Re: COM-18-011 Hahn Road Tower Upgrade with Removal Agreement
1st Review Responses
Verizon Wireless Project Name: CSP Calhan – 2-Way Emergency Radio Antenna

Subject: COM-18-011 Hahn Road Tower Upgrade with Removal Agreement 1st Review

T1

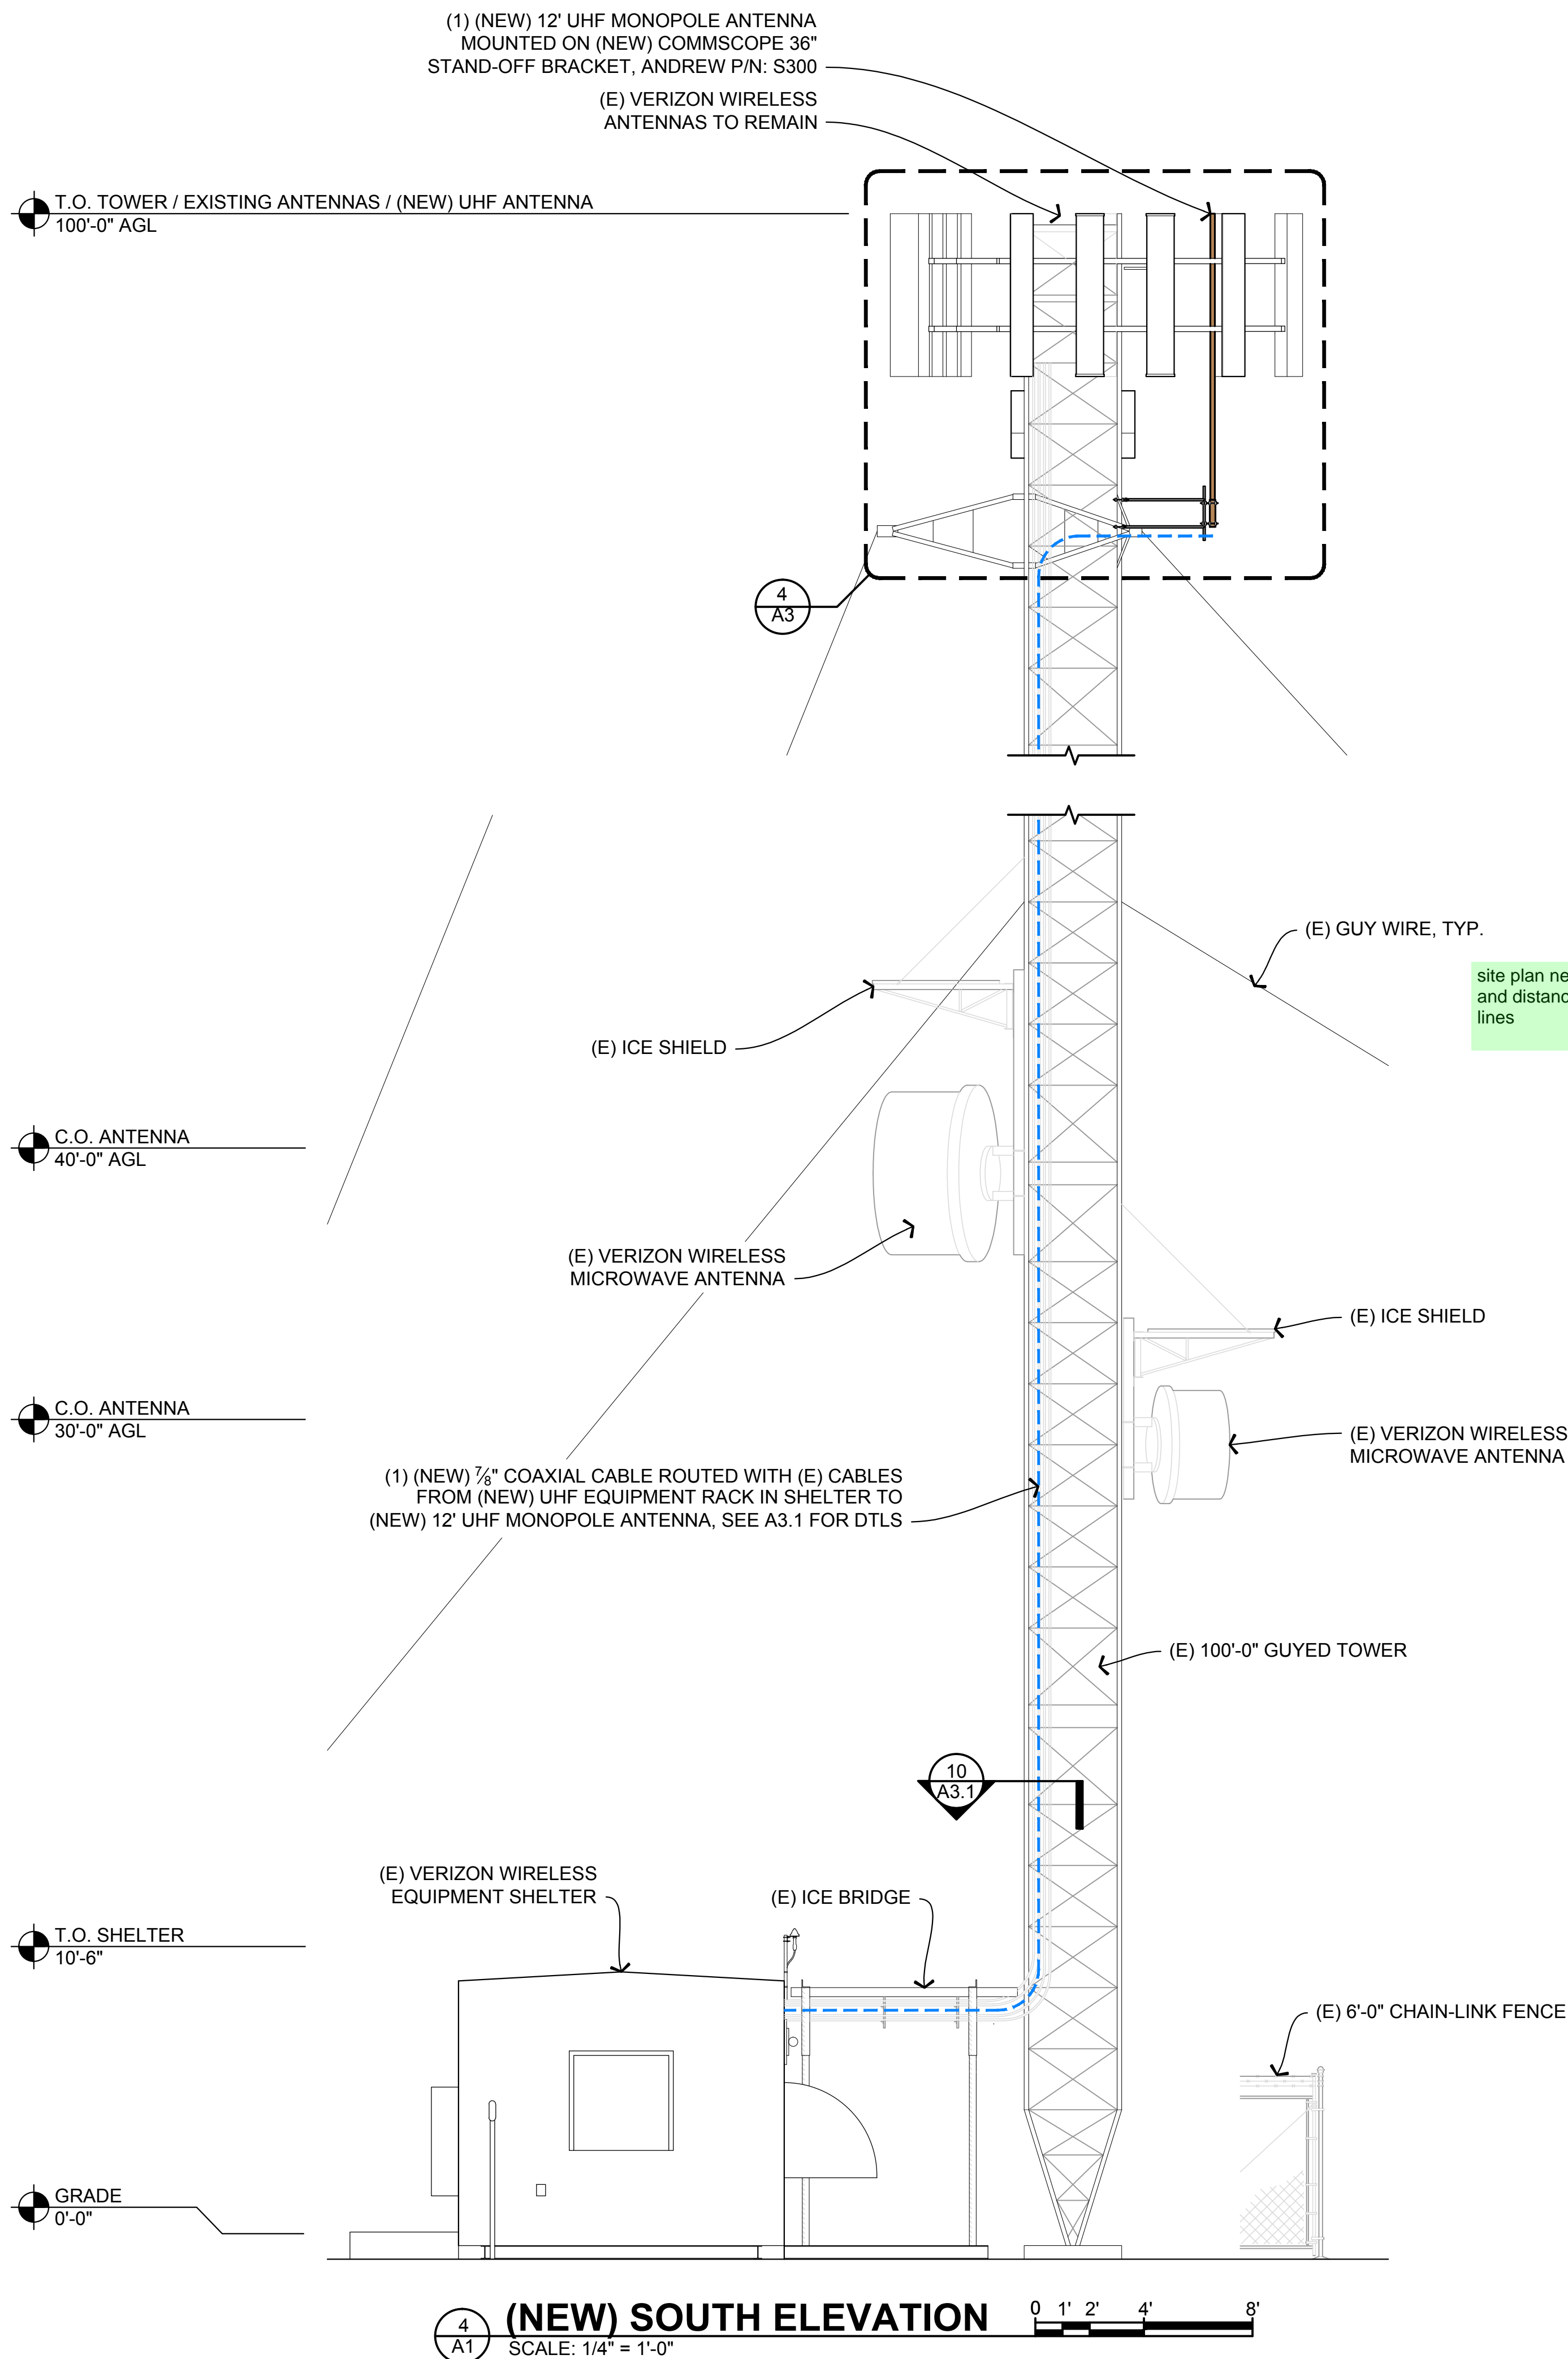
Engineering has provided comments on the site plan in the form of red lines. The Project Manager will upload that document for your use

1. **Redlines:** All redlines have been incorporated into the site plan drawings.
2. **Tower/Structure Removal Agreement:** A draft Tower/Structure Removal Agreement has been provided for County review before execution.
3. **Address Change on Bond:** The address on the bond has been revised. Final bond issuance will occur after second County review is completed in order to capture any additional revisions.
4. **Property Lines/Setbacks on Site Plans:** Drawings have been revised to show the subject property boundary and location of existing structures as well as dimensions to closest property line. Access to the site is shown and does not cross any adjacent properties. Please reference page A1-Plan (page 3 of 7) on the attached drawings

A1

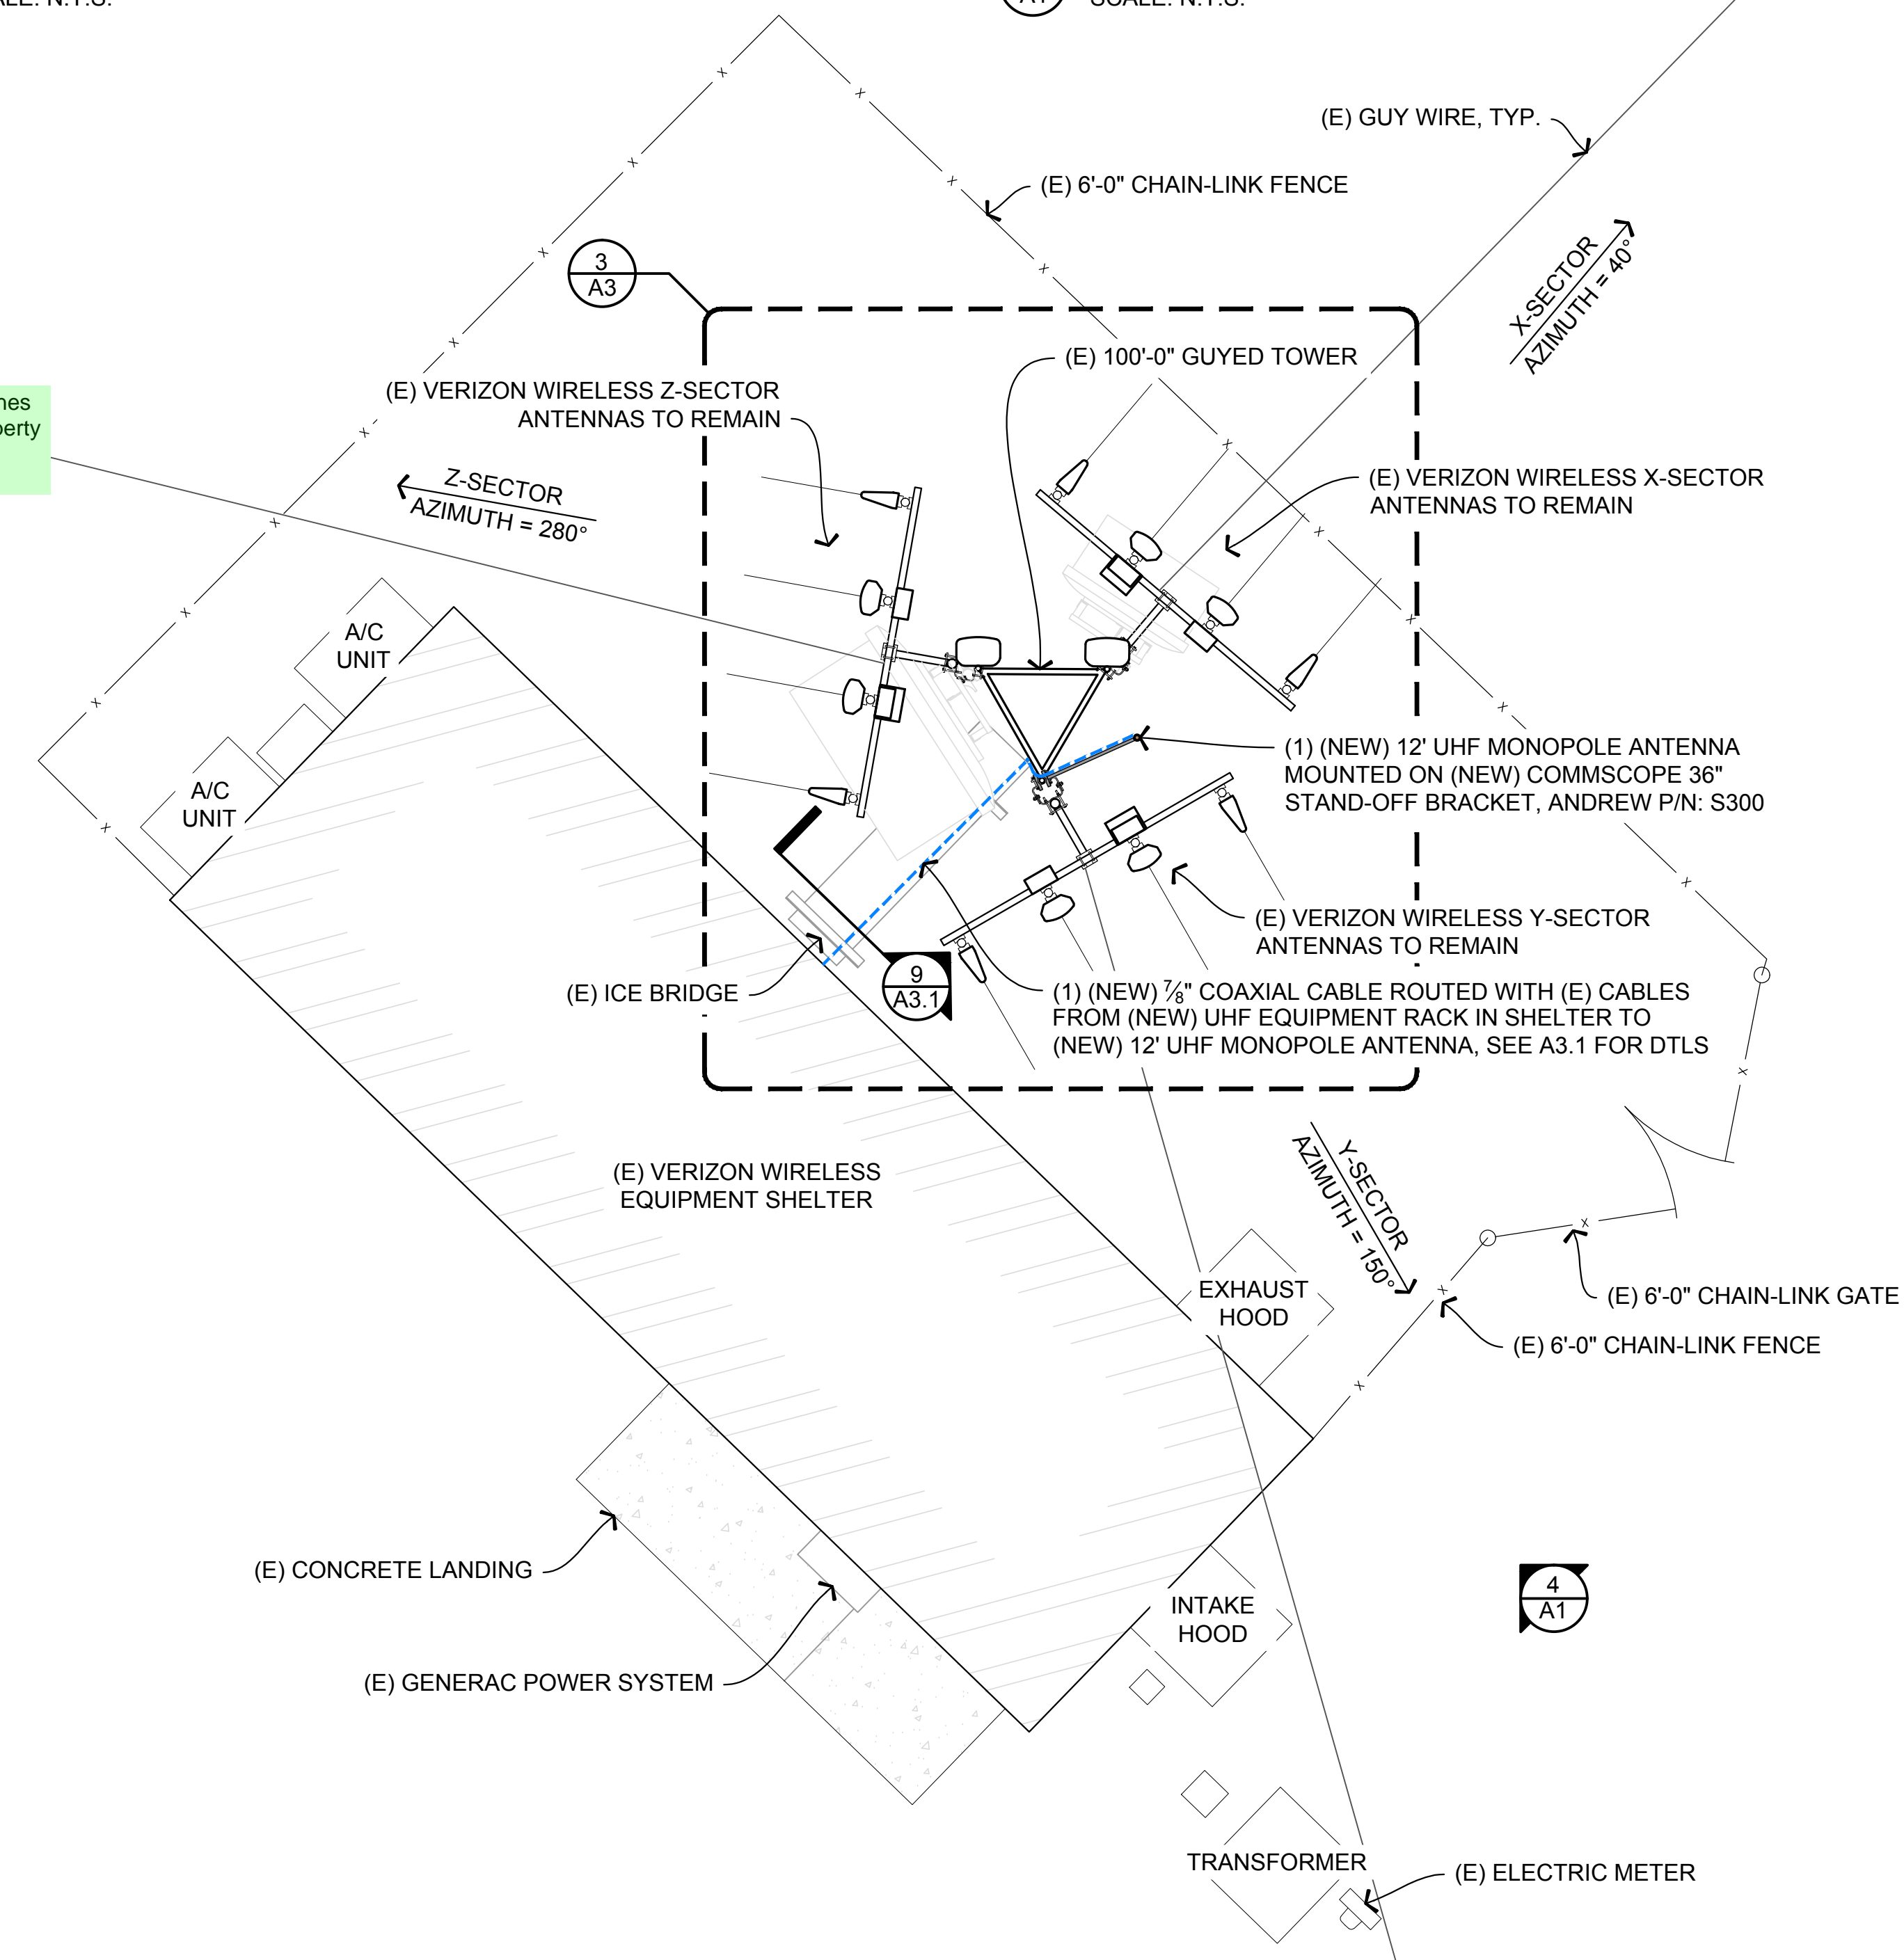
- See Redlines
- A Tower/Structure removal agreement was not submitted
- Please change the address for El Paso County on the bond to 200 S Cascade, Colorado Springs, CO 80903
- There are no property lines indicated on site plan, and no setback measurements for the tower or cabinet area.
